CITY OF ALBUQUERQUE

**RE: Central Take 5
5210 Central Ave SE Albuquerque, NM 87108
Grading and Drainage Plan (K17D080)
Engineers Stamp Date 9/12/2022**

Based upon the information provided in your submittal, the following comments must be addressed prior to Building approval:

09/12/2022 RONALD R. BOHANNAN P.E. #7868	CENTRAL TAKE 5 ALBUQUERQUE, NM	DRAWN BY BF
	GRADING AND DRAINAGE BASIN MAP	DATE 08/24/2022
	 TIERRA WEST, LLC 5571 MIDWAY PARK PLACE NE ALBUQUERQUE, NM 87109 (505) 858-3100 www.tierrawestllc.com	2022079_BASINS
		SHEET # C4.1
		JOB # 2022079

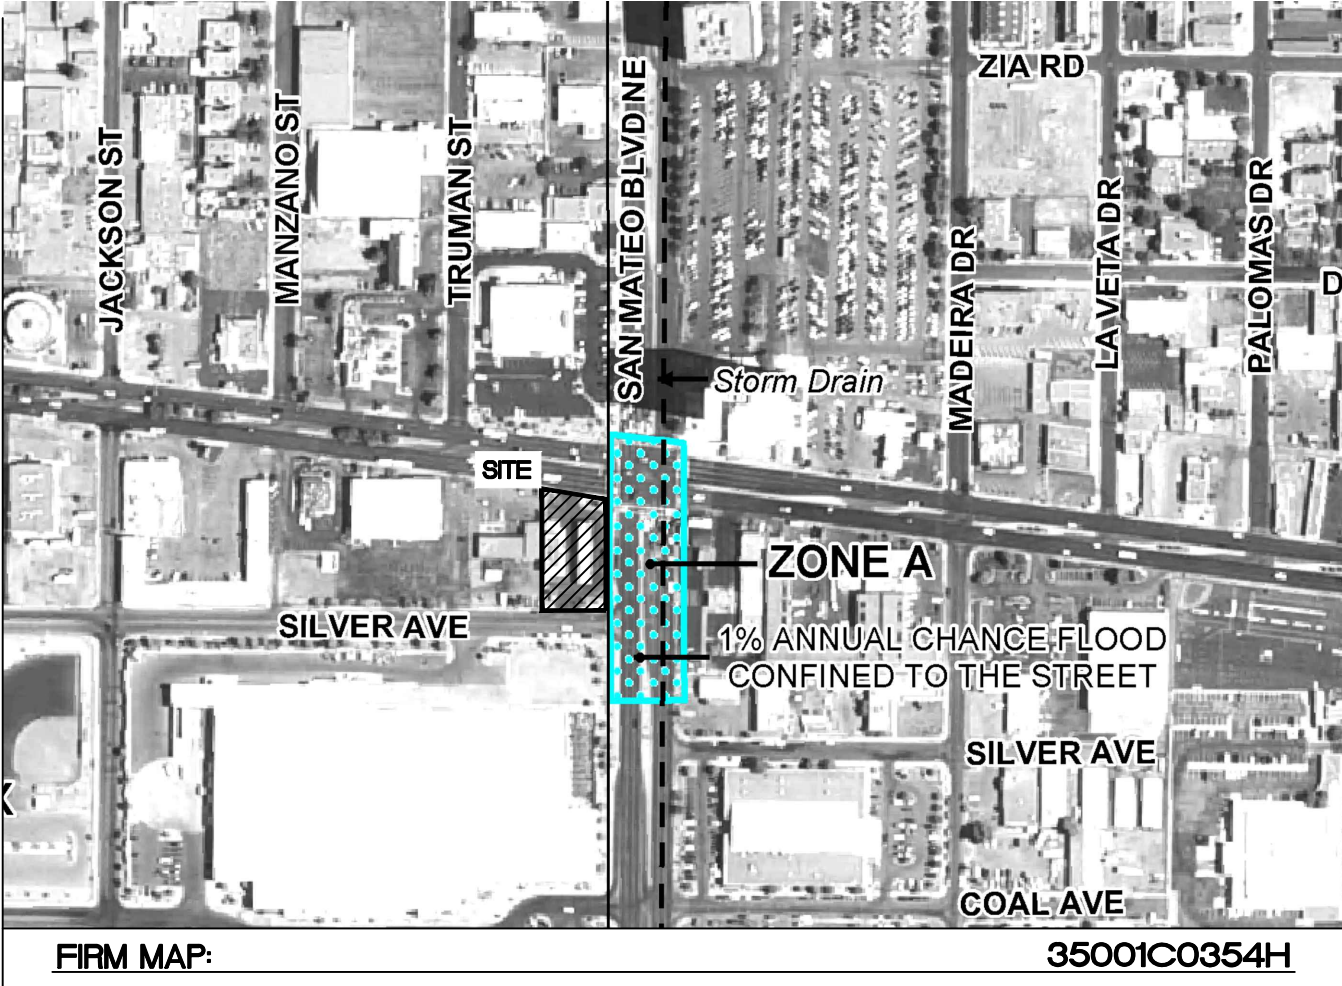
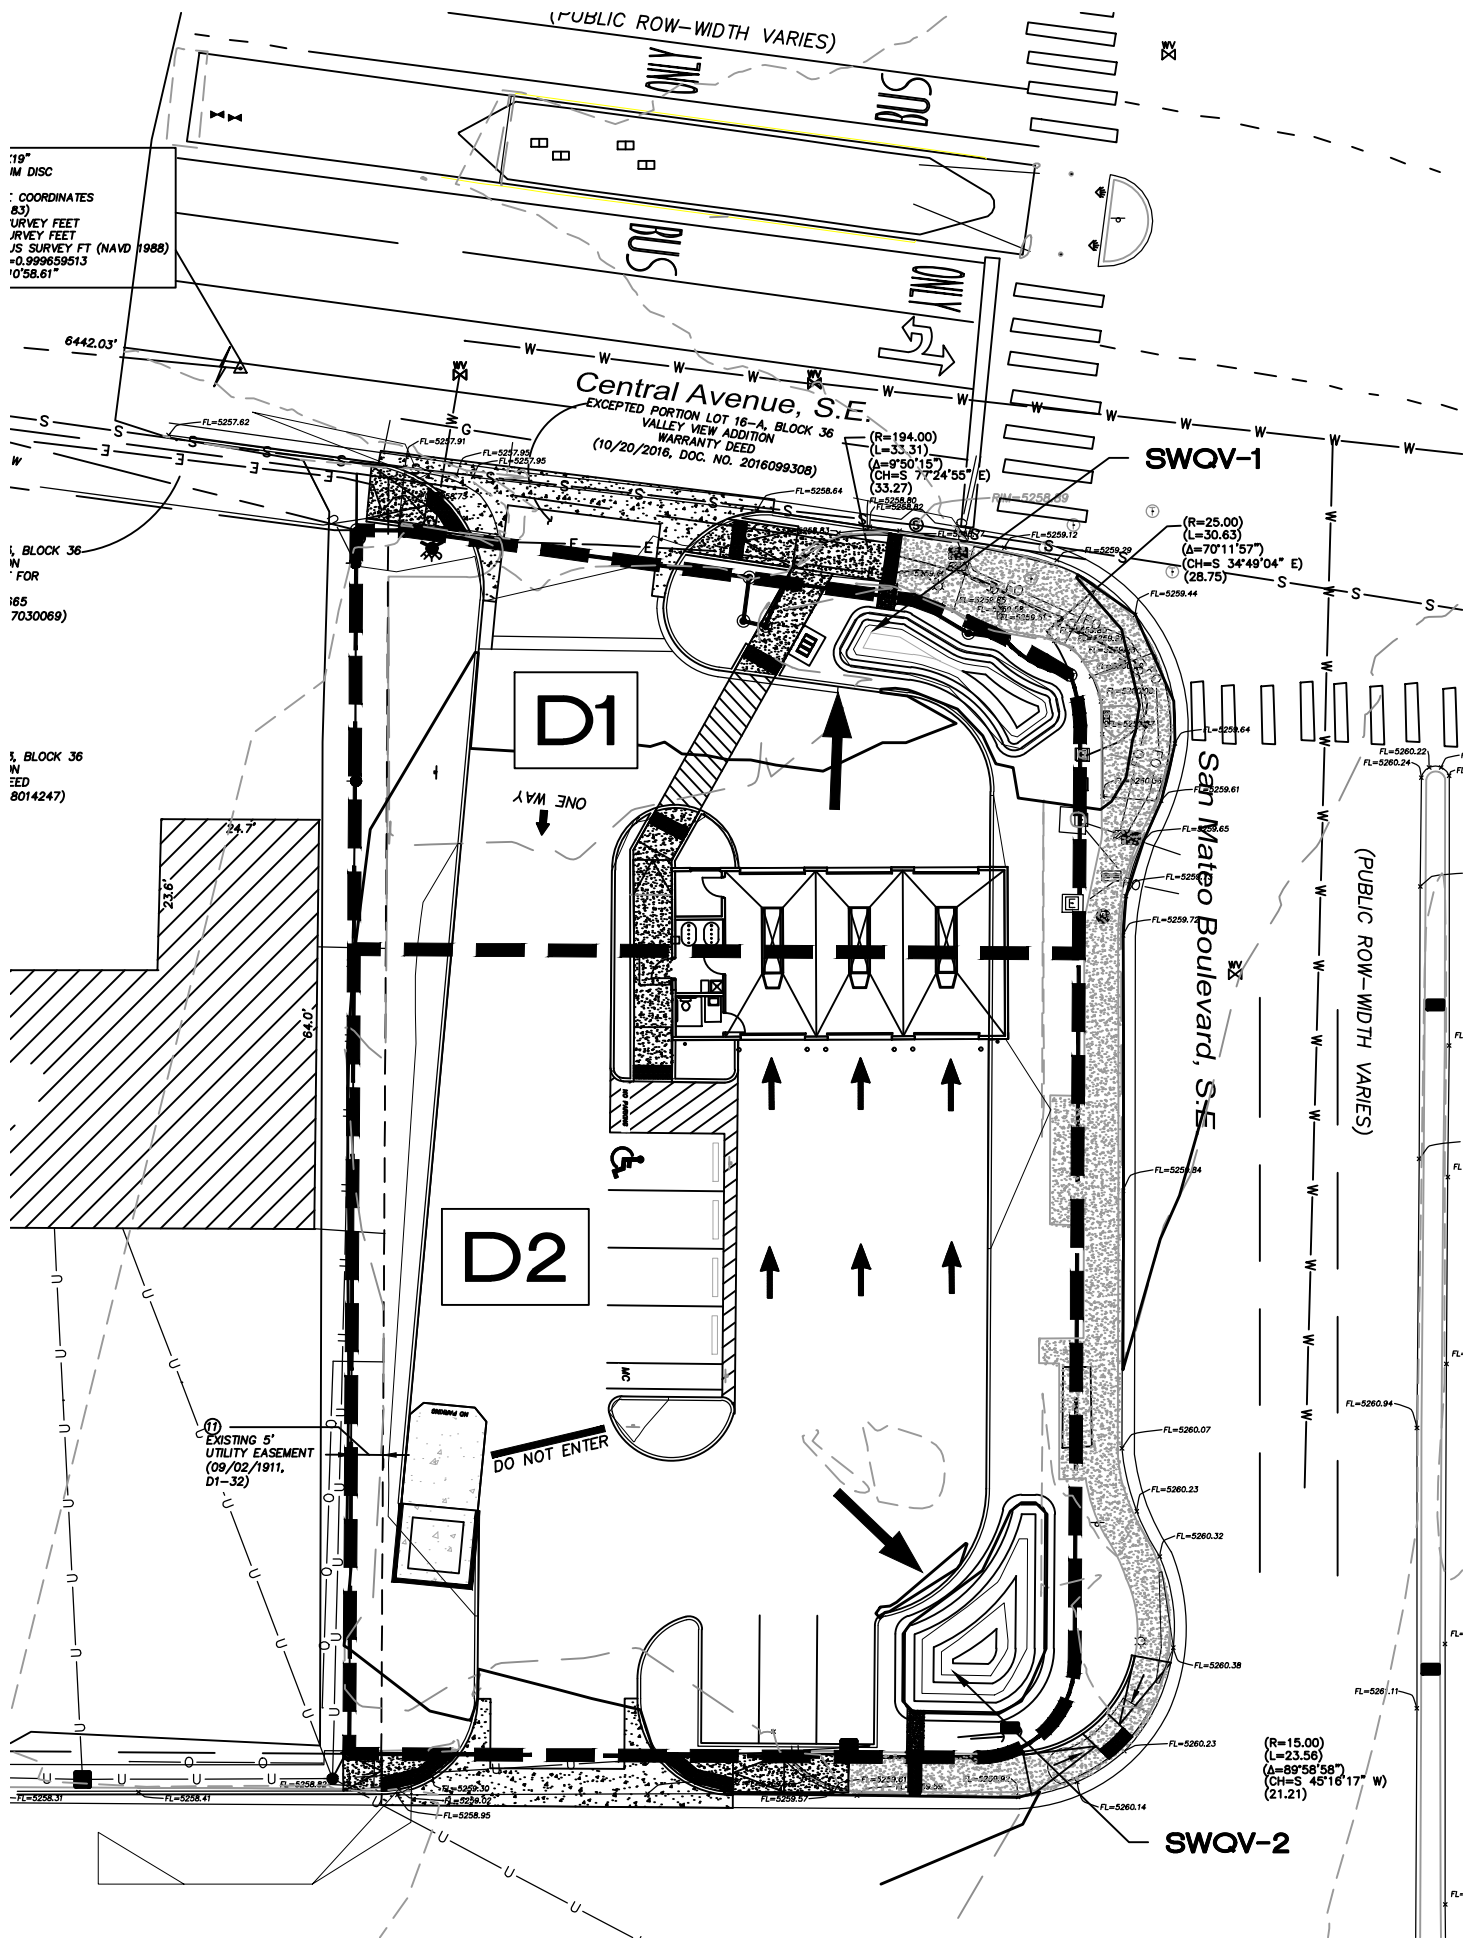
- 1) Provide SO-19 Notes.
- 2) Pond volume appears to be more than what is shown on the plans. Please double check the calculation.
- 3) Additional contour lines are shown within the pond.
- 4) Show all existing easements (if any). Please ensure that proposed ponds are not encroaching in an existing easement. Are there existing bus shelter easements on this site as well?
- 5) A recorded Pond Covenant will be required for the proposed ponds on-site prior to Final Certification of Occupancy.
